Application Ref:	3/2026/0049			 Ribble Valley Borough Council www.ribblevalley.gov.uk
Date Inspected:	10/02/26	Site Notice:	10/02/26	
Officer:	LW			
DELEGATED ITEM FILE REPORT:				APPROVAL

Development Description:	Demolition of existing side car port with erection of single storey rear extension and two storey side extension with integral garage.
Site Address/Location:	11 St Peters Close, Clayton le Dale, BB1 9HH.

PROPOSED FRONT ELEVATION

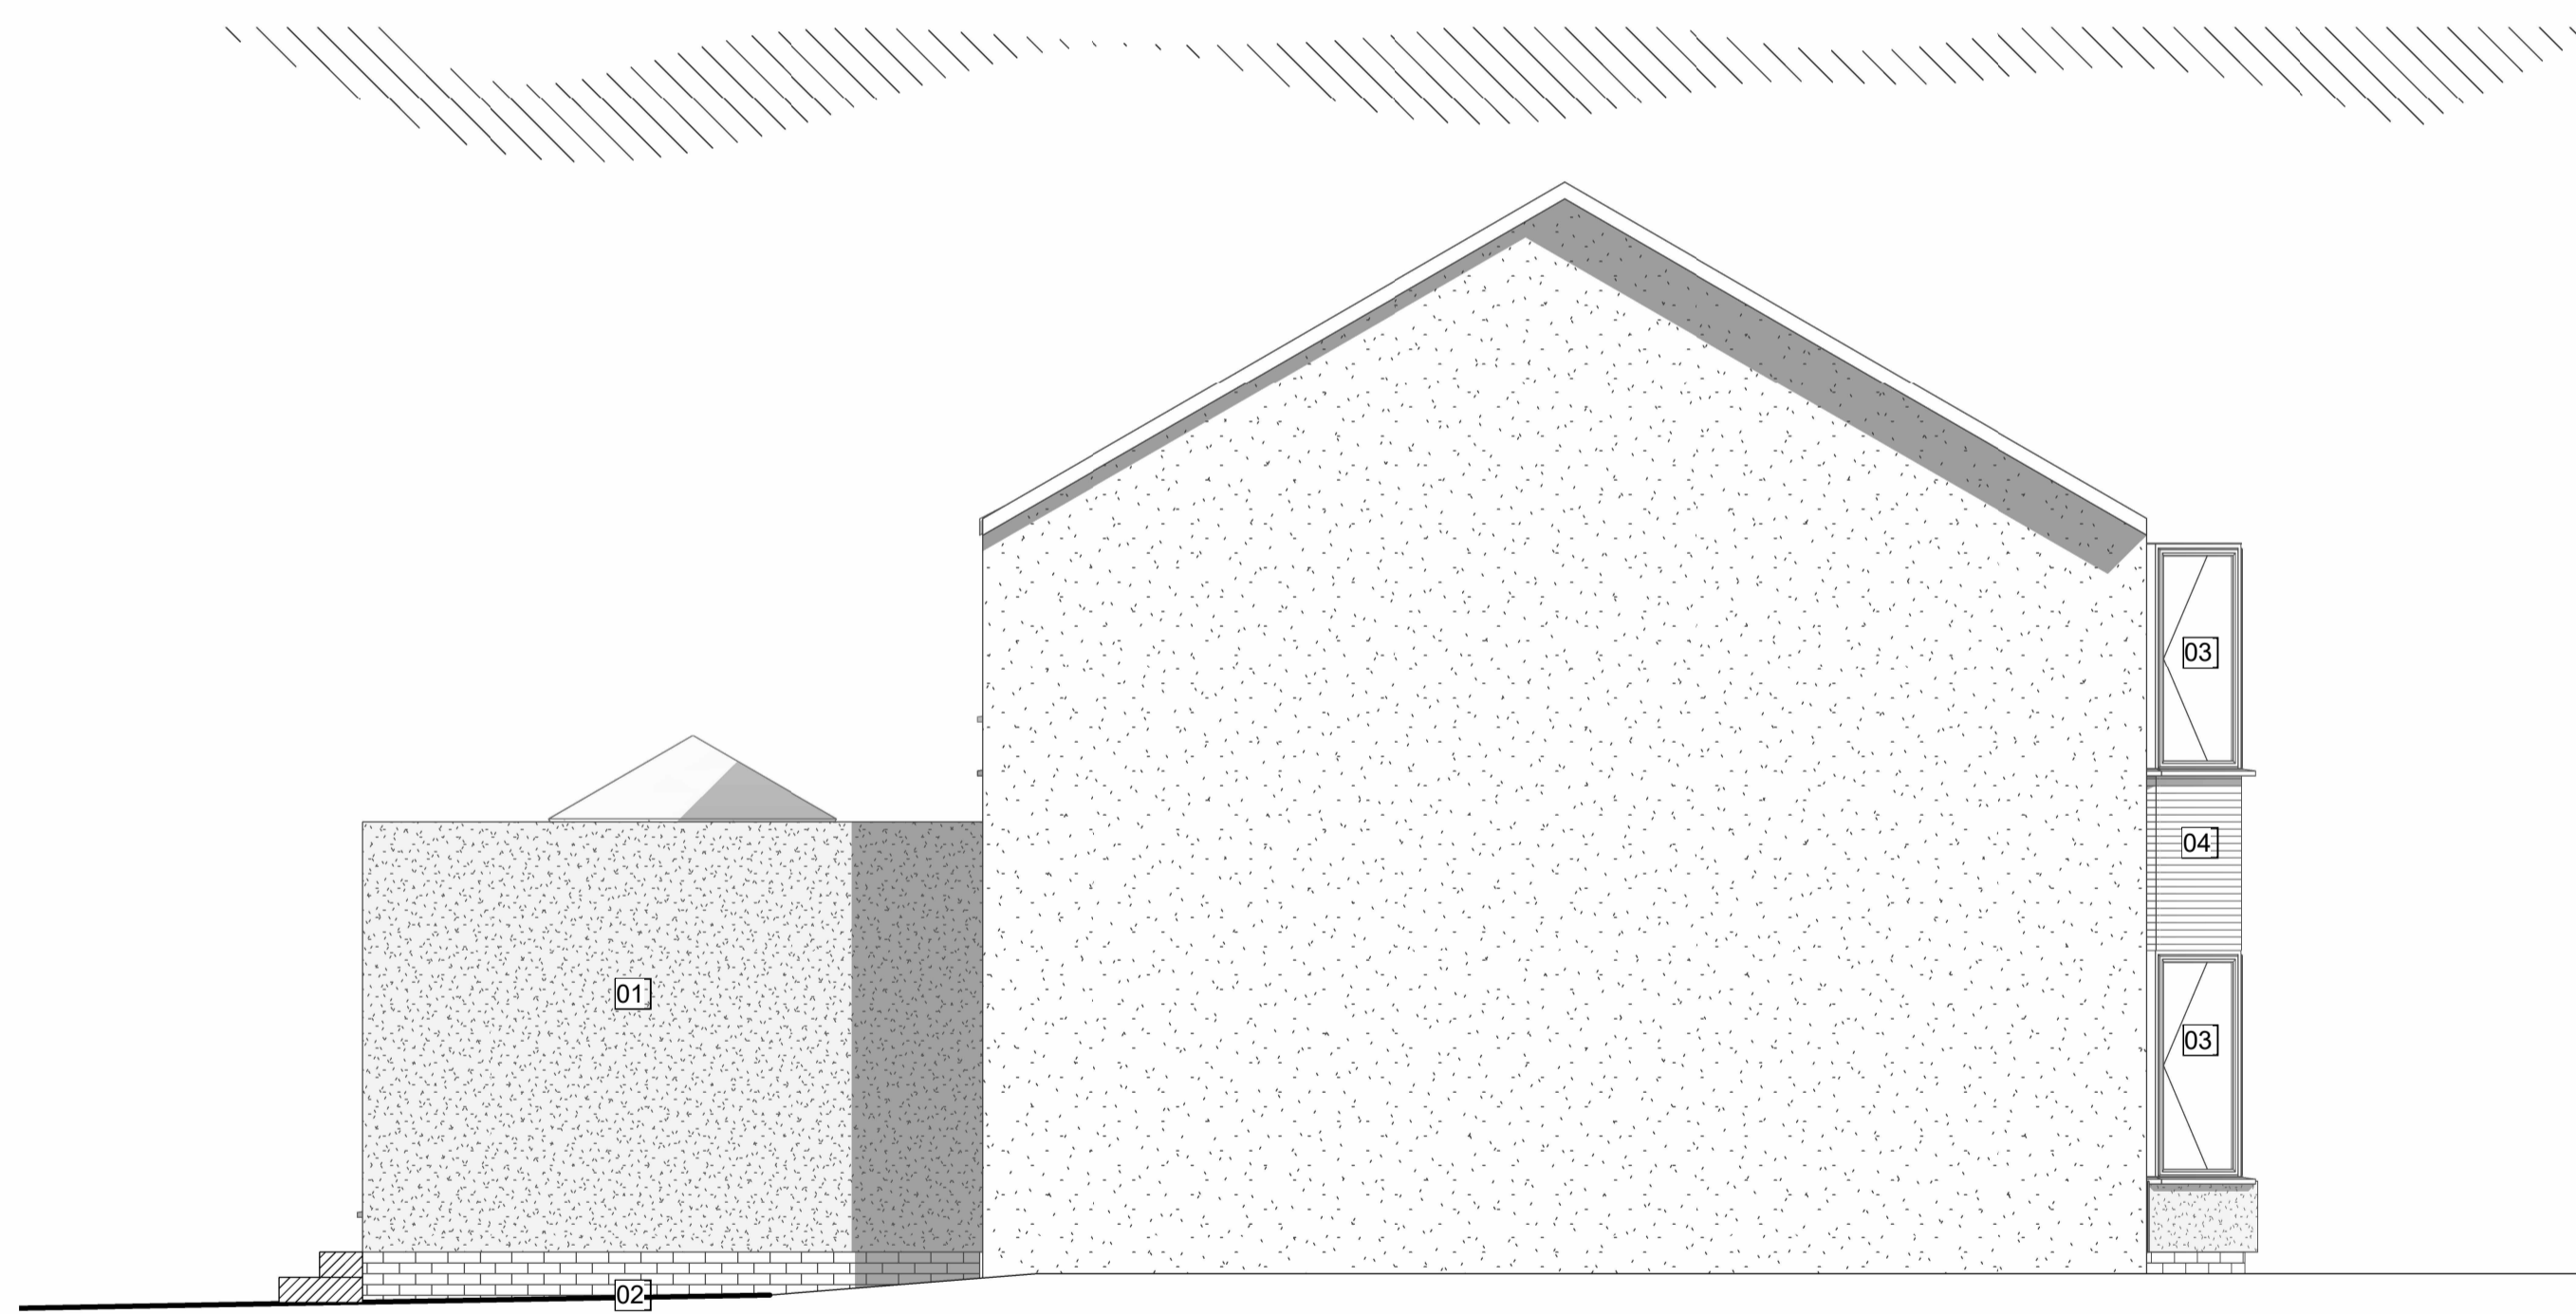
In most cases, the Local Planning Authority seek to ensure that two storey extensions are adequately set-down from the main ridgeline and set-back from the principal elevation so as to ensure that the proposal appears subservient to the main dwellinghouse. In this case, whilst the proposal originally submitted with the application included a marginal set back of 0.3m from the principal elevation of the application property, this was not considered sufficient enough to ensure that the proposal clearly reads as a subordinate addition to the original built form of the property.

Following discussions with the Agent, an amended scheme has been submitted which shows a 0.6m set back from the principal elevation, to match the first-floor set back of the two-storey side extension featured to No.8 St Peters Close which was approved under application reference 3/2014/0407. This, together with set down from the main ridgeline, is considered acceptable. The sideward projection of the extension would also not be significant to an unacceptable degree when read in context with the existing built form of the property.
